From: Simon Davis
Sent: 19 February 2019 11:05
To: Planning.Responses; Laura Gibbons
Subject: FW: Planning Consultation on: BE/131/18/PL
Attachments: 1808-SK2.pdf; PP1.pdf; SA1.pdf; SA2.pdf

Engineers comments regarding requested amendments to conditions 9, 10, 11 and 12

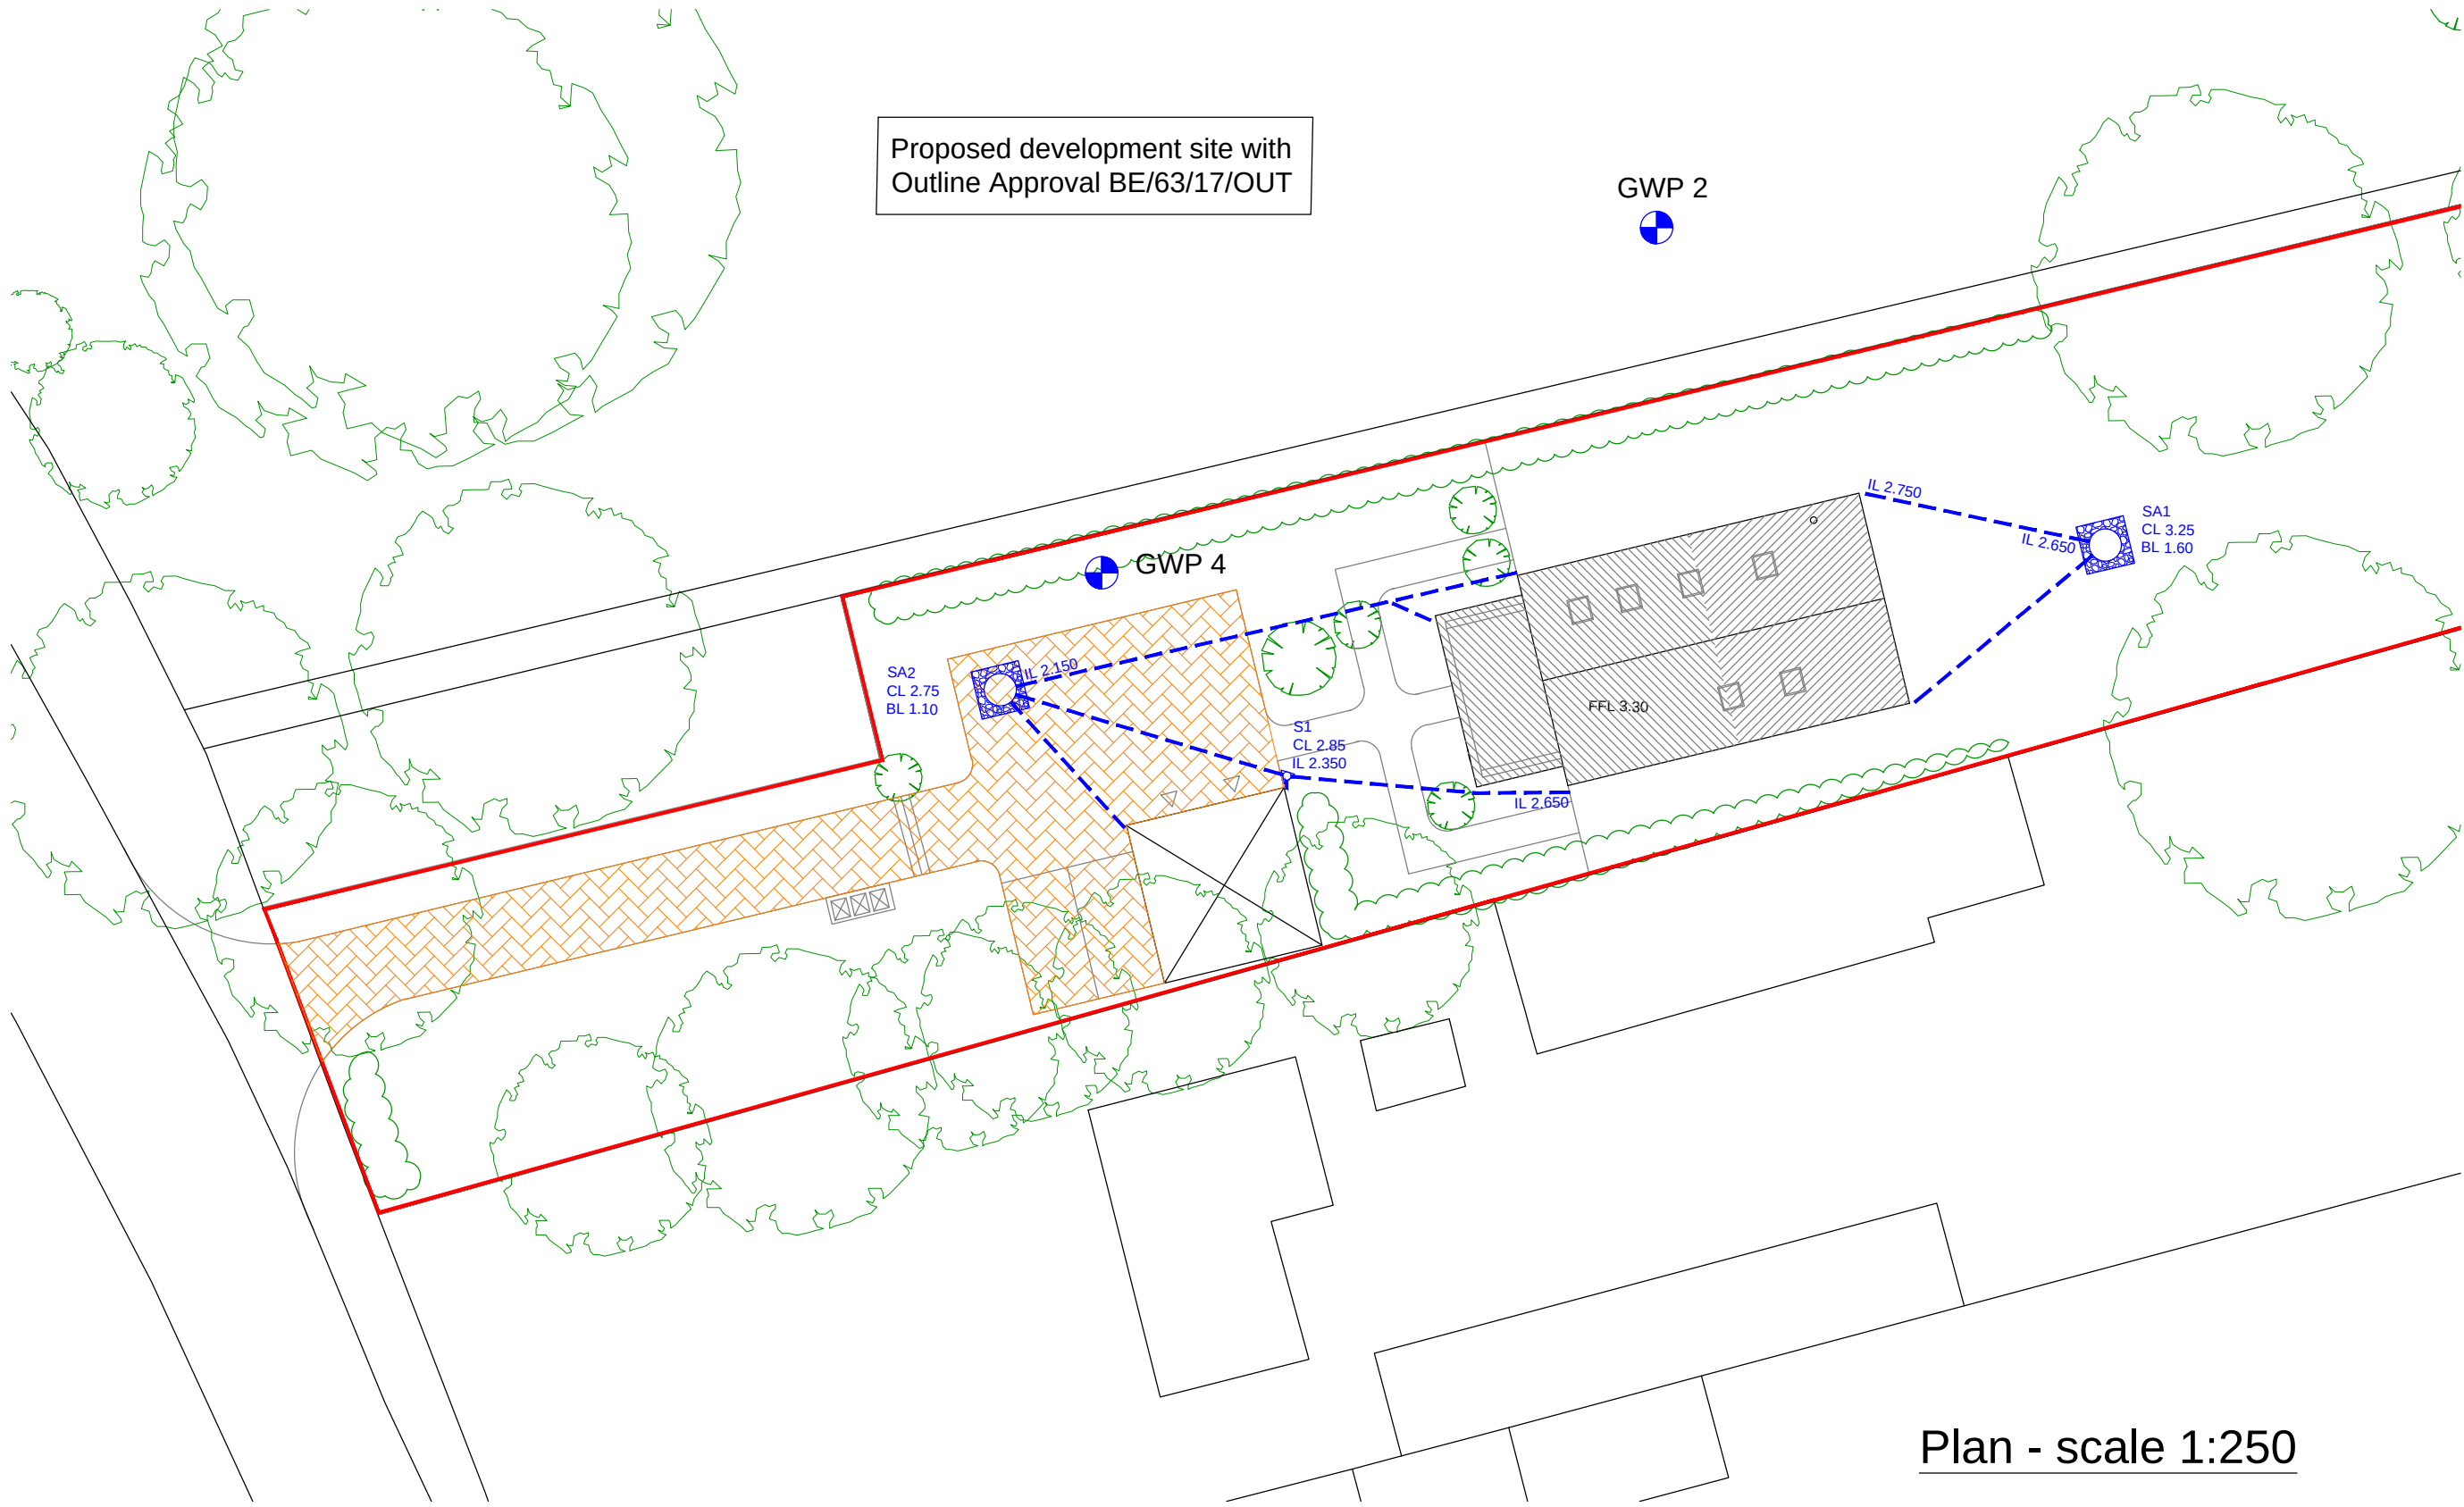
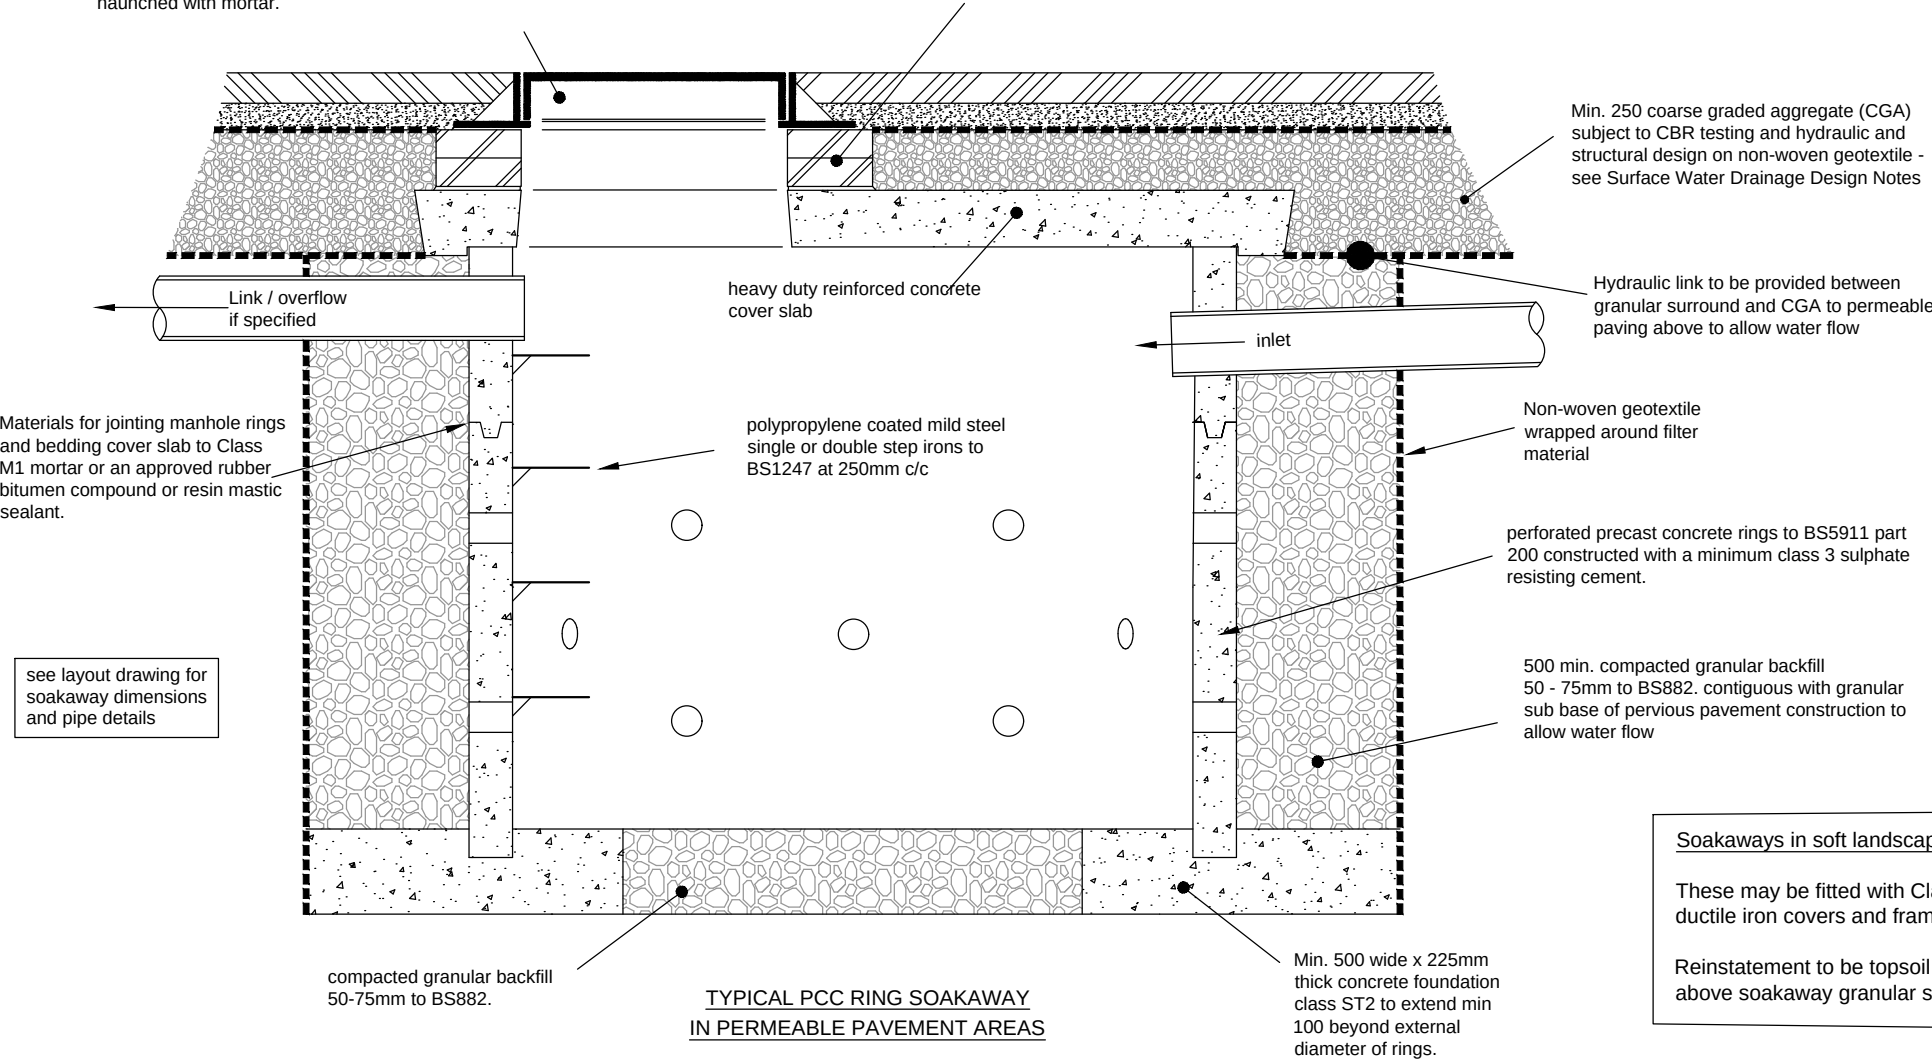
I was not initially aware but it transpires that groundwater monitoring had been undertaken at The Cottage, Shripney Road for a number of months. Please find attached the results of this monitoring and a plan showing the proposed drainage strategy for the proposed chalet bungalow to the south (phase 1). As you can see from the plan, the proposed method of surface water disposal is via a combination of permeable paving and soakaways.

“For a one dwelling replacement we wouldn’t require winter monitoring October to March inclusive, just a couple of dips. Therefore, the applicant could do some monitoring and infiltration testing for phase 1 now, and complete full monitoring and infiltration testing for phase 2 next winter. As stated previously, if the results aren’t good and rule out infiltration, the drainage system for phases 1 and 2 will likely need to be interlinked. Hence, I cannot comment as to condition 11 until monitoring results are available for phase 1.”

It is unclear what winter groundwater levels are at the site. If it is found that groundwater levels are too high to permit infiltration, or that infiltration is too slow even phase 1 will have to drain to the ditch. Without winter groundwater monitoring phase 1 wouldn't comply with building regulations approved document H. It is possible that the drainage of phase 1 and 2 will need to be interconnected. Therefore I do not recommend the alteration to conditions 9, 10 or 11. However, I am satisfied that the wording of condition 12 can be amended.
